Application number: 2026/90484	
What is the application for?:	Change of use from dwelling to C2 for 4 children, erection of first floor extens
Address of the site or building:	143, Church Lane, Gomersal, Cleckheaton, BD19 4QN
Postcode:	LS27 7HB

Proposed First Floor General Arrangement Plan 1:50

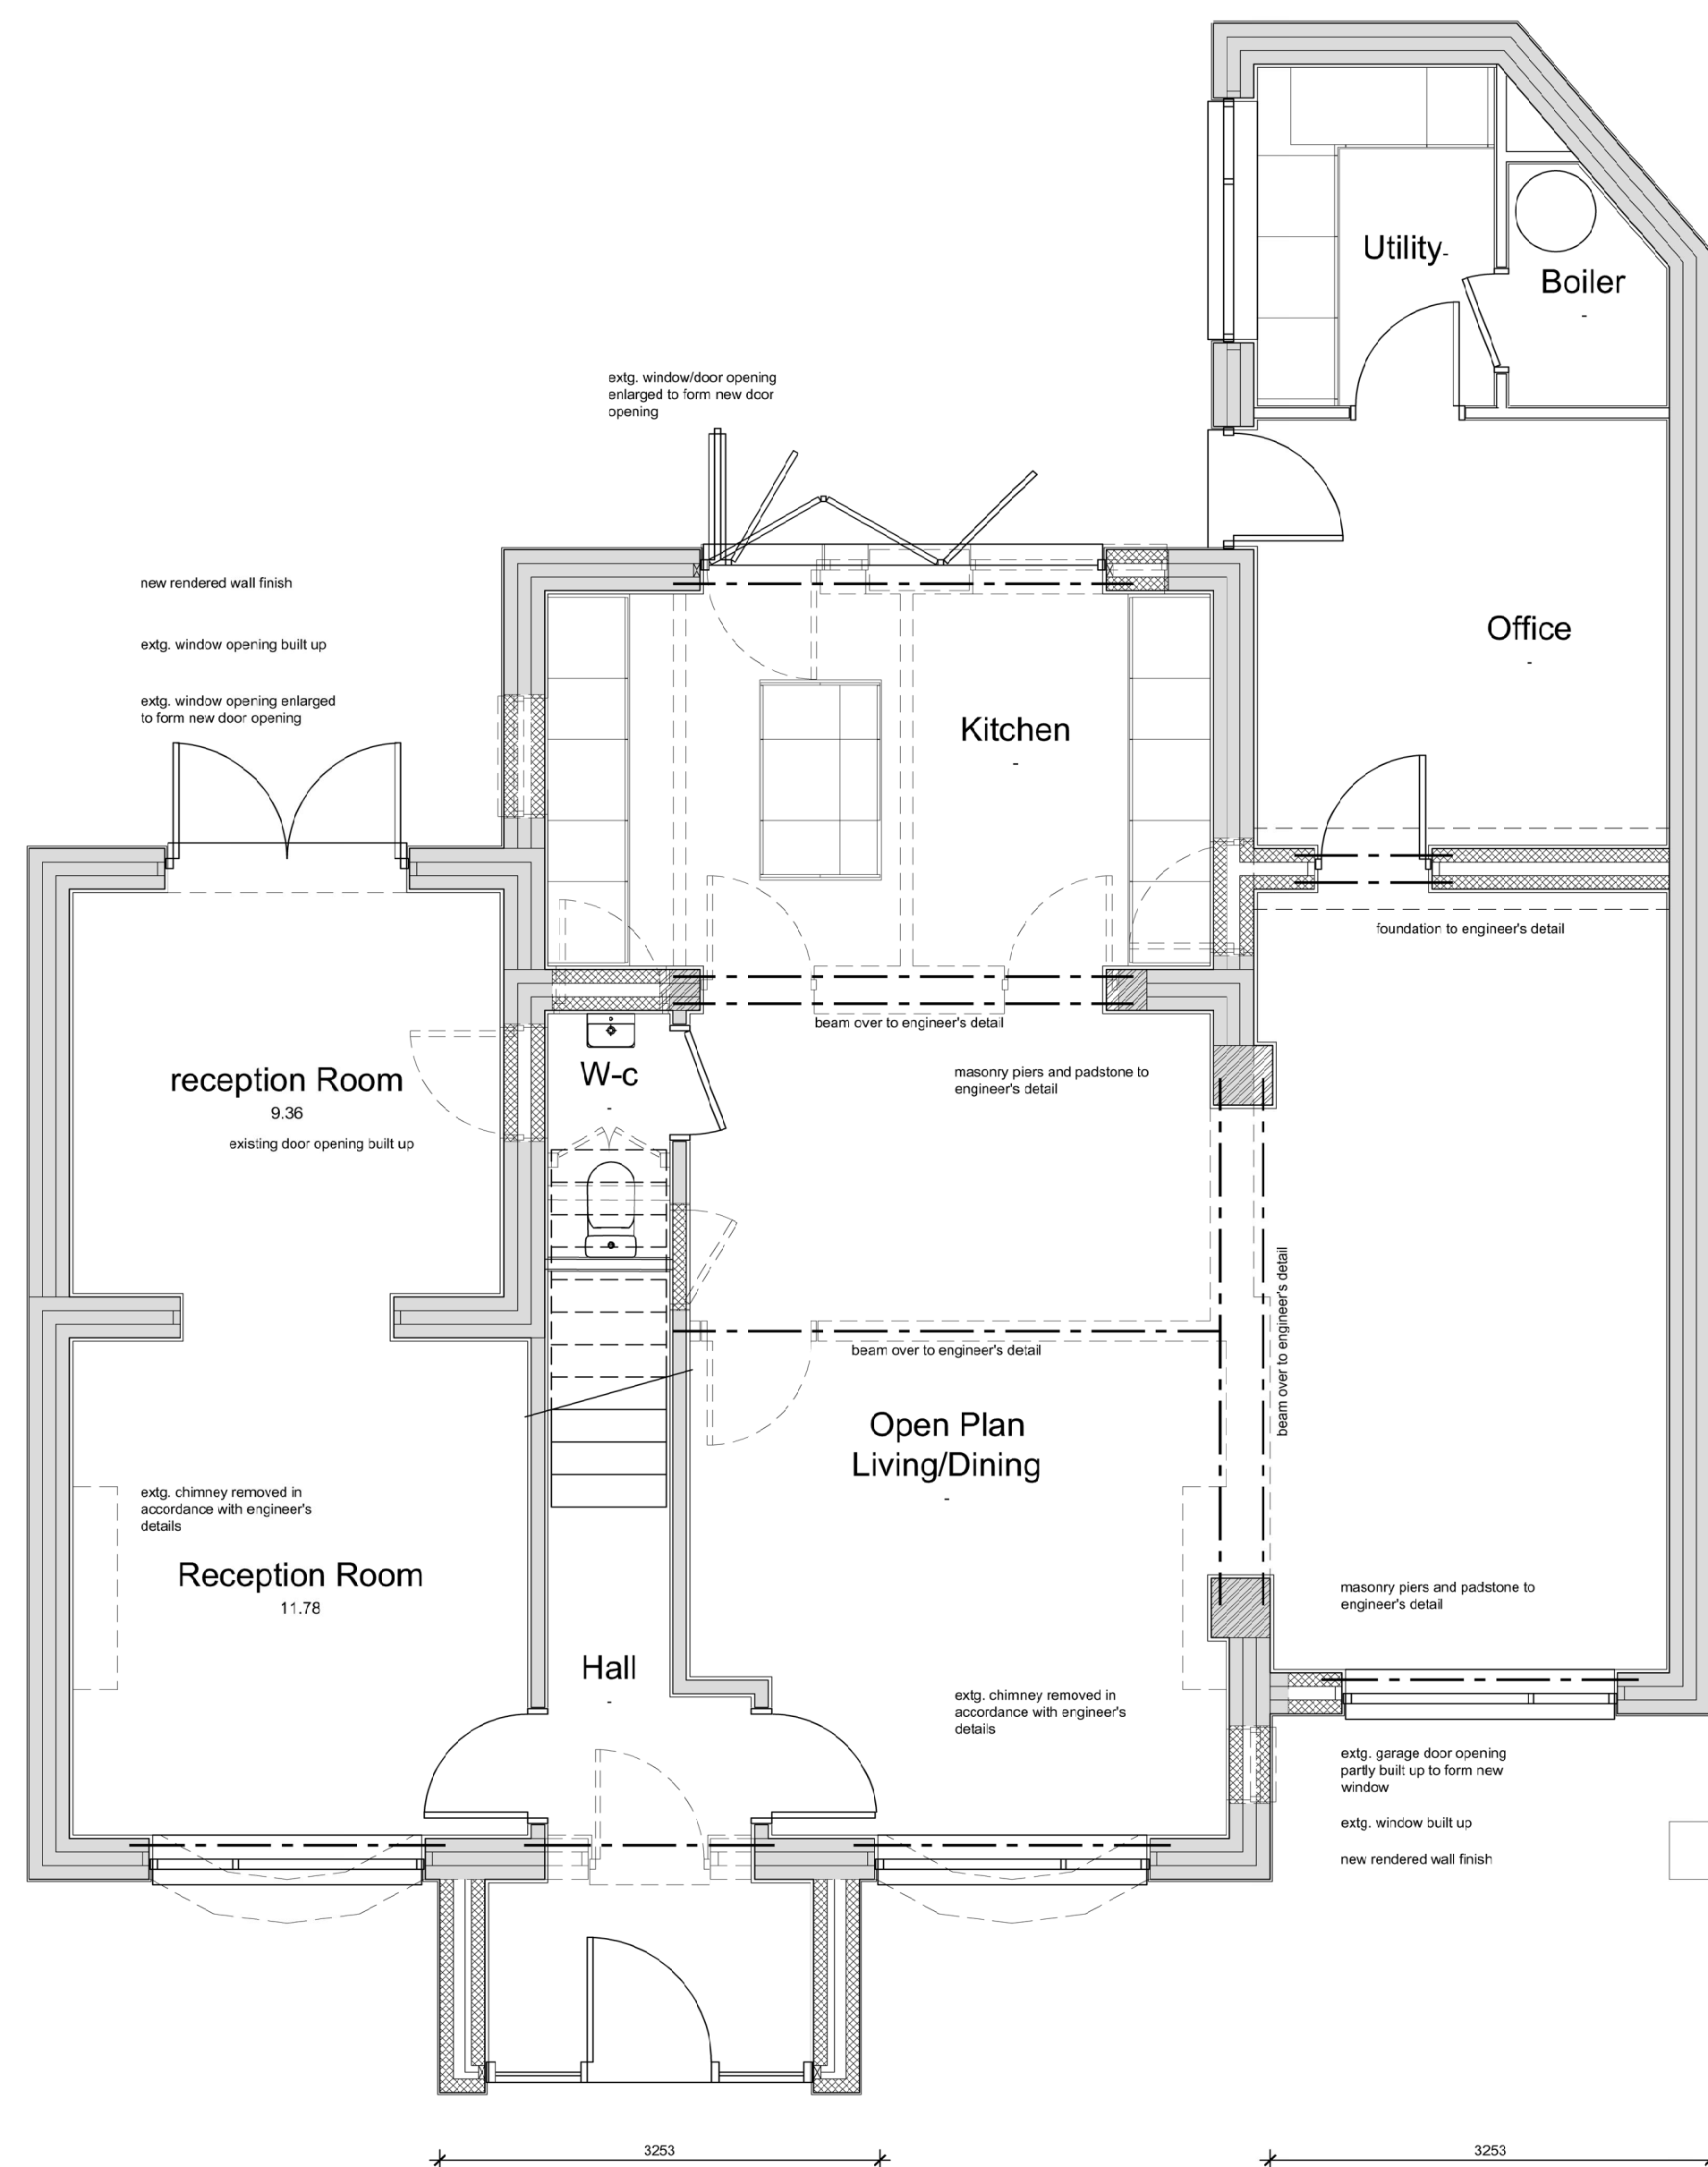
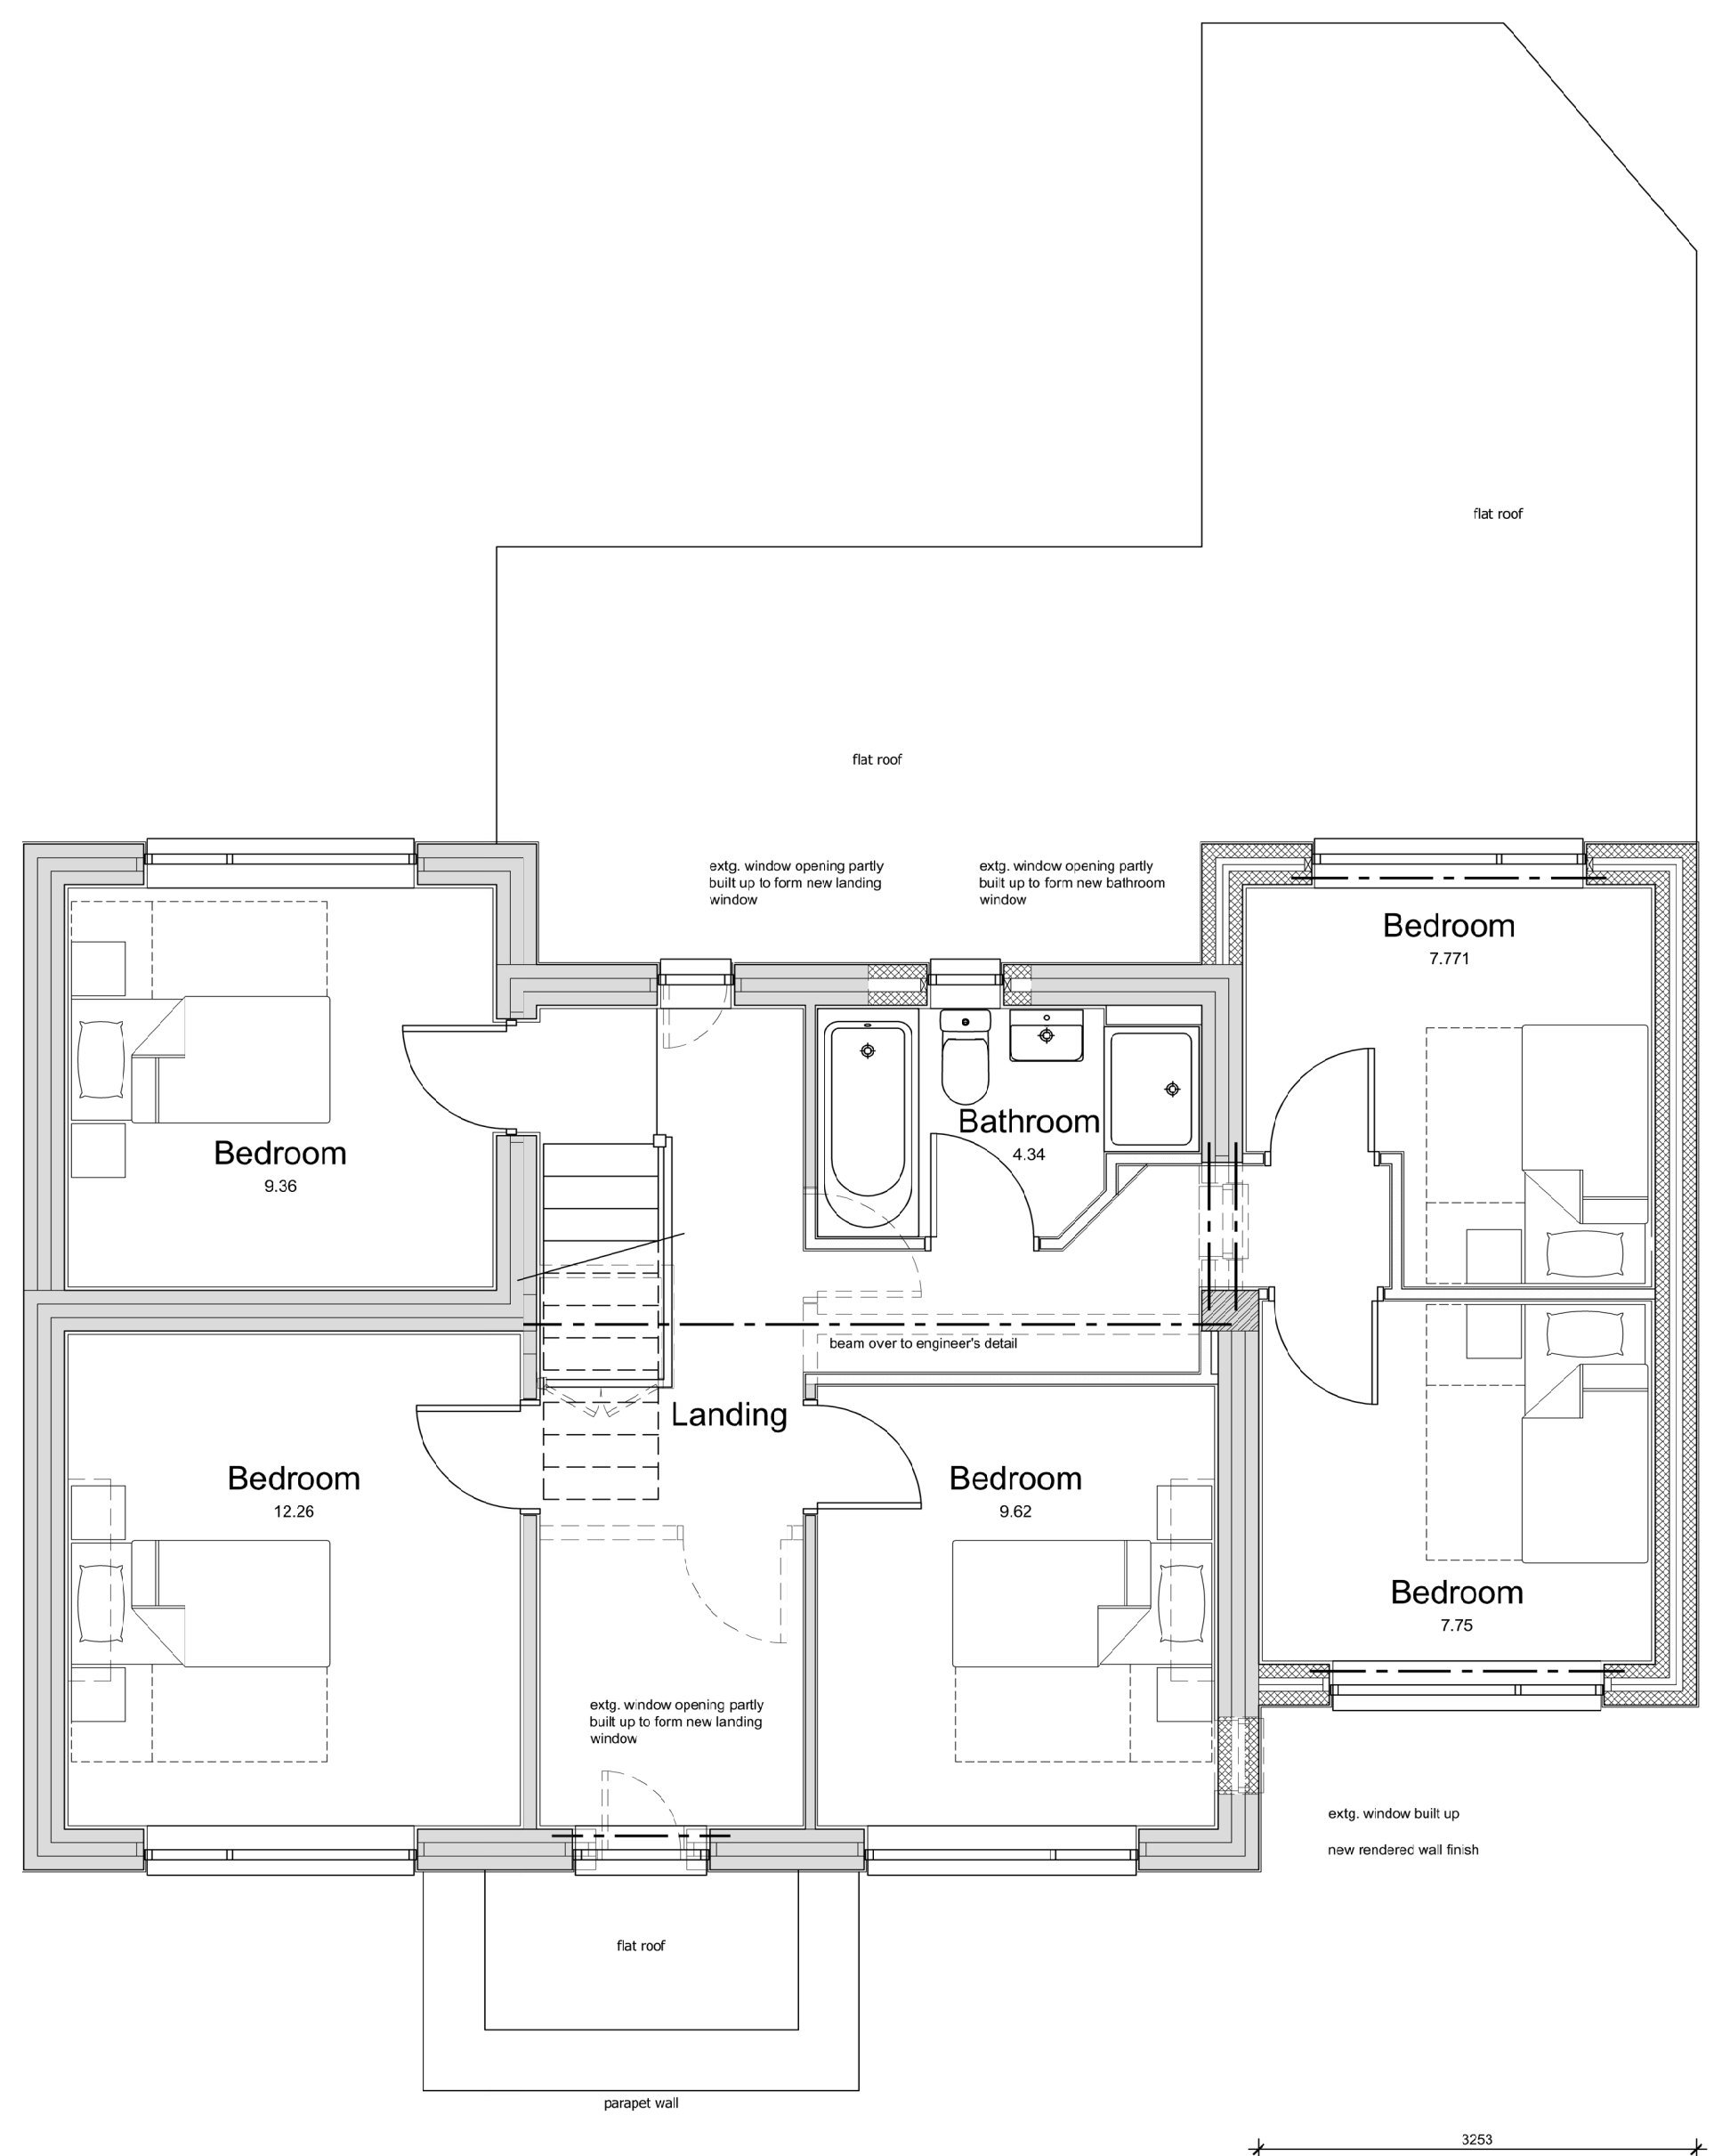
Type of comment: An objection	
Do you wish your comments to be published on the website anonymously?	Yes
Security and Safeguarding Concerns The property layout raises concerns regarding safeguarding and resident safety. For example: • Upper-floor windows that should function as fire escapes could allow residents to access a flat roof and exit the property into neighbouring gardens on The Coppice with ease • Boundary fencing between neighbouring properties is currently low and easily climbable • The property is located directly opposite a bus stop with frequent services to Huddersfield and Leeds. Research by Biehal and Wade (2000) found that children in residential care are significantly more likely to go missing compared with those in foster care. Government research (DFE-RR201, 2010) reported that 60% of residents in surveyed homes had gone missing within a six-month period. Given these statistics and the above shortfalls in the property as well as the location of the current bus stop, the proposed site raises concerns about whether adequate safeguarding measures can realistically be implemented and significantly increase the likelihood of the possibility of residents going missing.
